2015/1997/MAJ

Comments from Highway Authority received 19.1.2016.

In respect of the proposed planting in verge around the Comet Hotel, Comet Way – I can advise that a discussion with Network Management suggests that an application for a license to plant would not be looked upon favourably, or supported

CLIENT FUSION RESIDENTIAL		
PROJECT HOTEL & STUDENT RESIDENTIAL COMET HOTEL SITE HATFIELD		
TITLE LANDSCAPE_GENERAL_ARRANGEMENT INDICATIVE_LANDSCAPE_SECTIONS_2_OF_3		
Status: PLANNING	Drawn: MM	Checked: BS
Scale: 1:50@A1	Date: 24.09.15	Approved: BS
Drawing Number: 2821_L_GA_2_02		Rev: 00

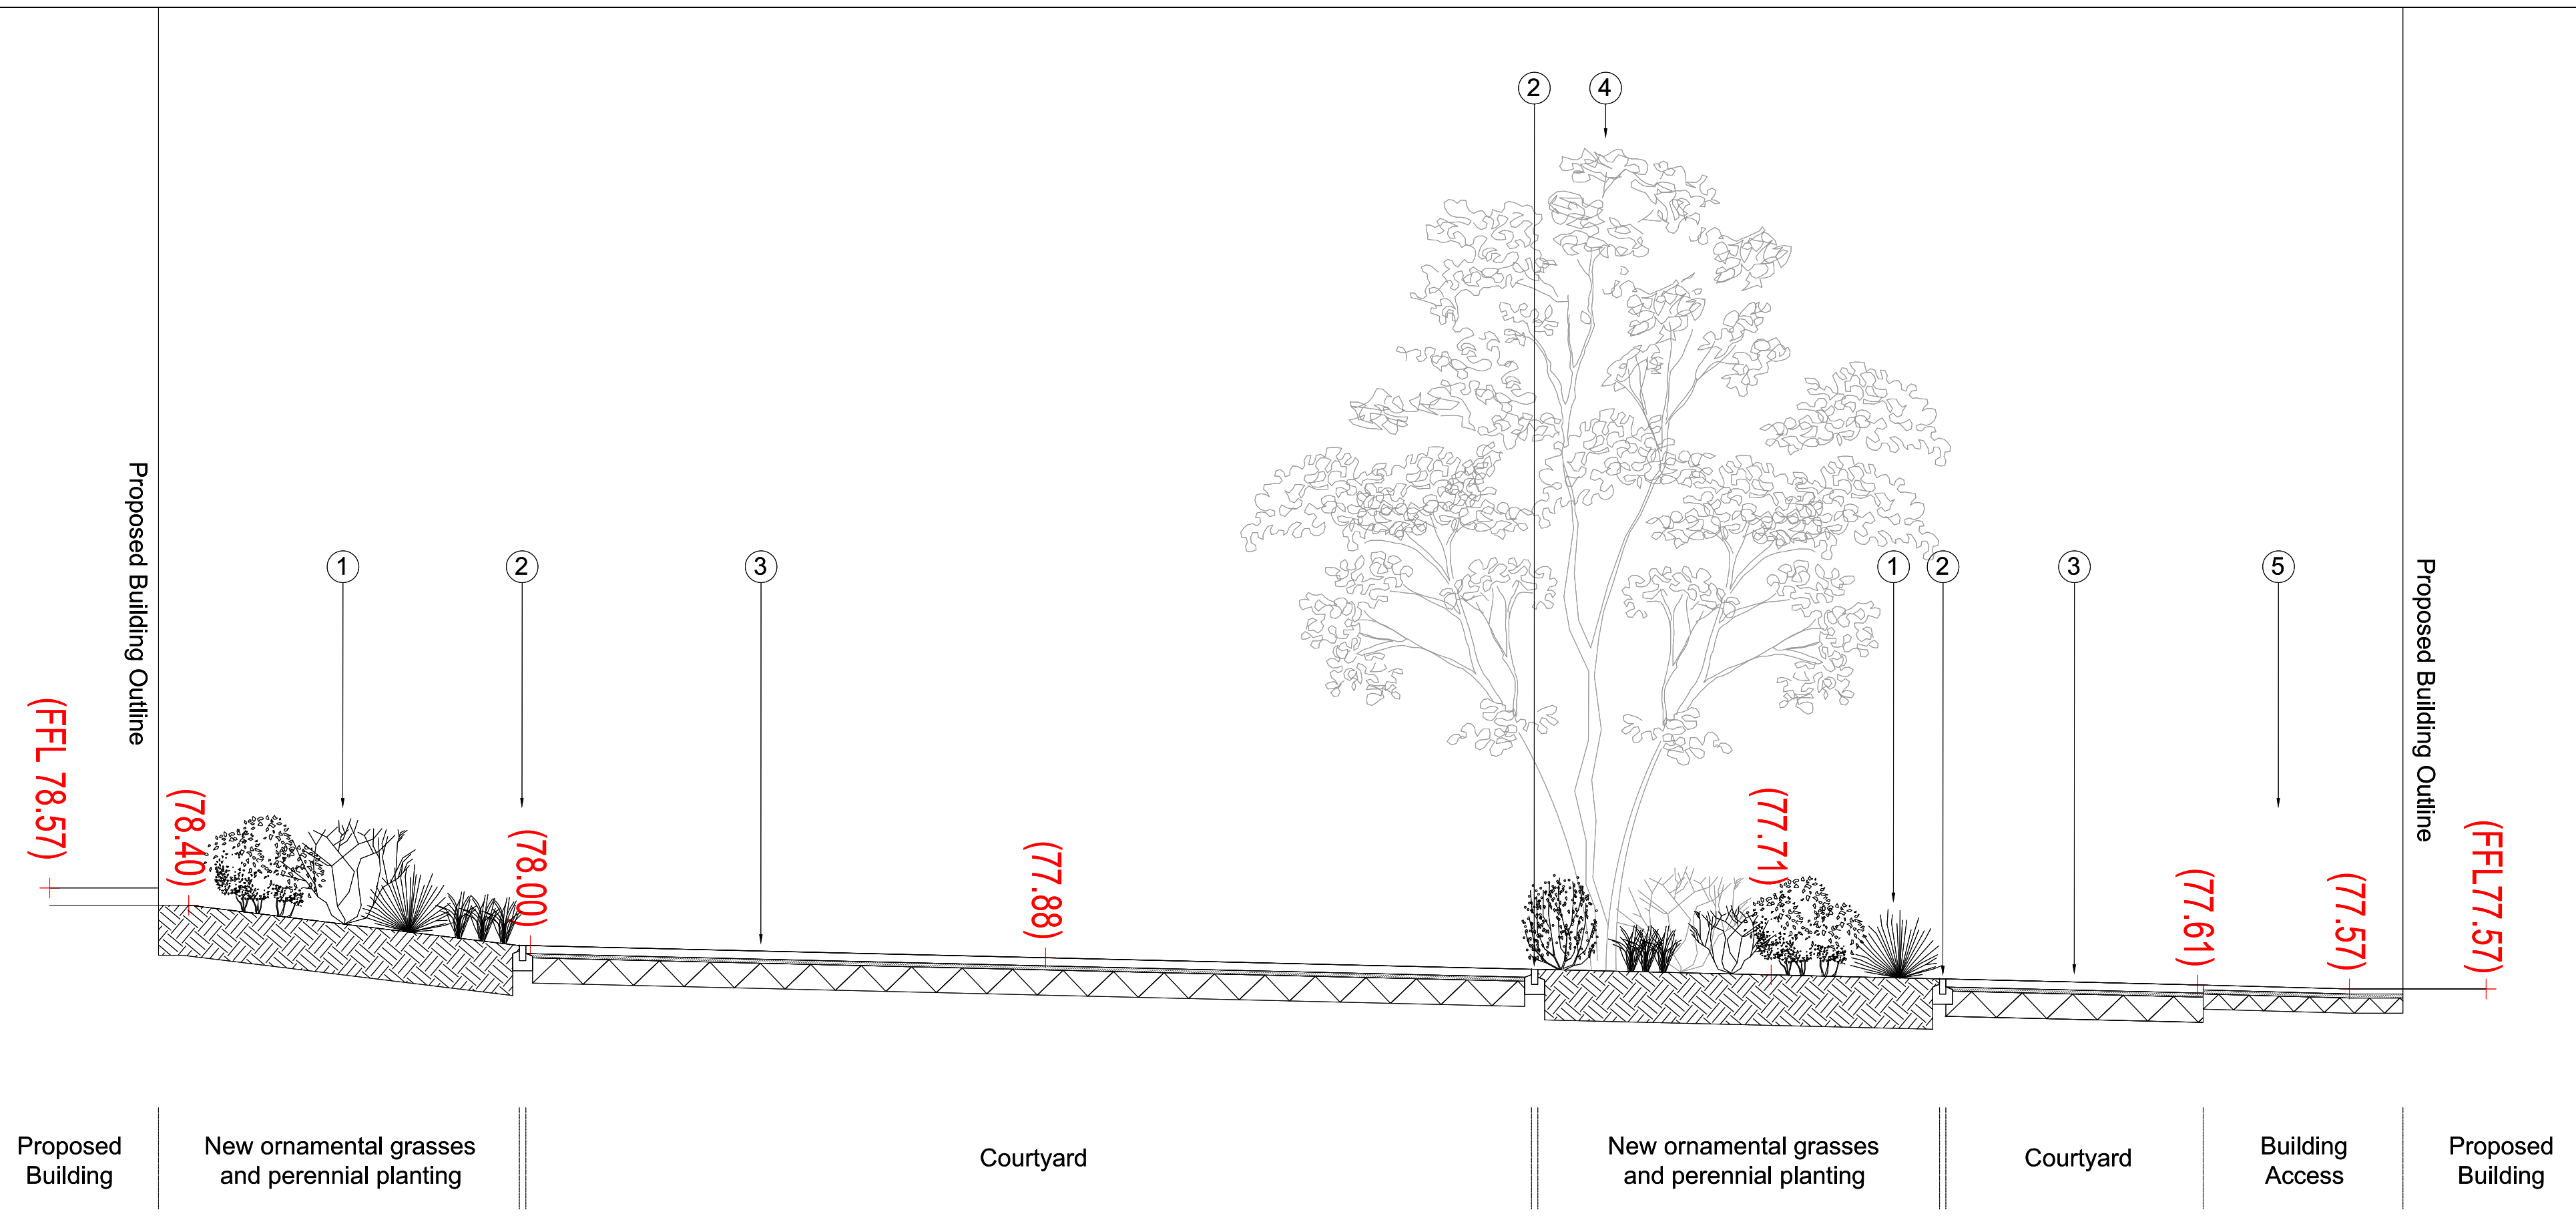
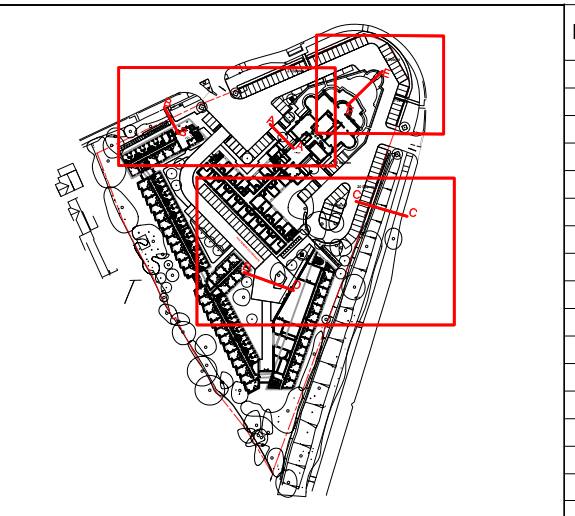
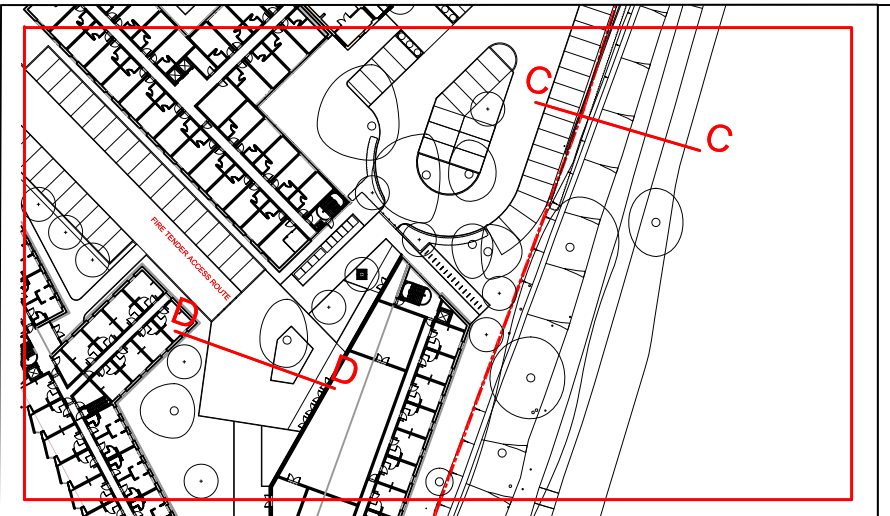
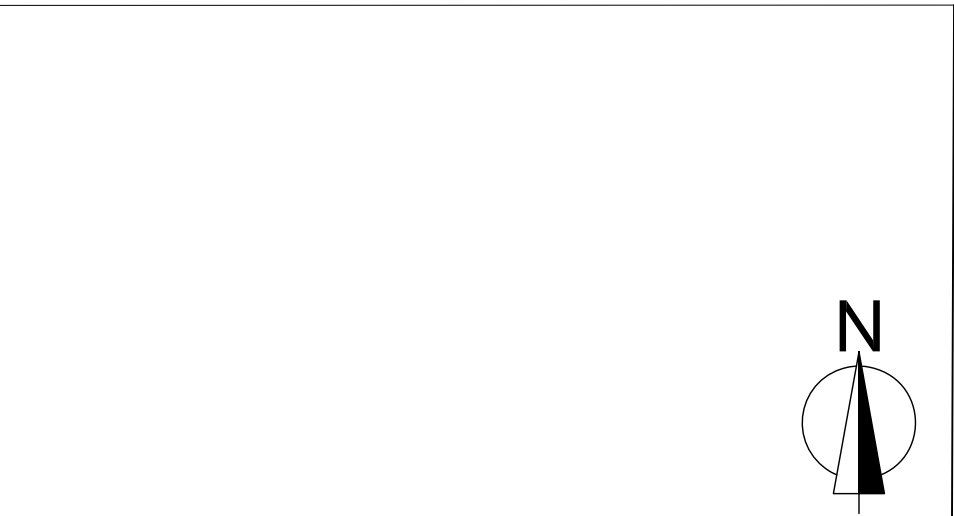
The provision of the vegetation provides no benefit to the highway authority, but importantly shall place a burden upon the County Council to monitor compliance with the provisions of the license (i.e. that the vegetation is checked to ensure that it not overgrown, excessive in height), and given that such resources are limited introduces a risk that without adequate monitoring may exceed the heights we've previously discussed. The requirement for the height itself was to ensure that the hedge did not result in obstruction to visibility across the junction within the limits of the highway verge. I would observe that the above discussions included an appreciation that the planting species had changed, and was being suggested as box hedge, but that despite the slow growing nature of such vegetation the above concerns remained.

Clearly the necessary license is issued under the provisions of the Highways Act, and therefore separate to any consent issued under the TCPA within the planning application you are considering. Any grant of consent shall require the applicant to obtain separate permission from the Highway Authority (by way of the license) to implement, and as above, such authority would be unlikely to be given for the necessary license.

I would suggest therefore that the hedge be omitted from the planning application, or pushed to within land within the applicants control rather than highway verge, thereby ensuring consistency between the TCPA consent and the highway authorities position on this in respect of the provisions of the Highway Act.

If however you are minded to approve within the application, then I would request that an appropriate informative be applied to the decision that directs the applicant to the above requirement, and I would strongly recommend that they be informed that any such approach in this matter is unlikely to be successful for the above reasons.
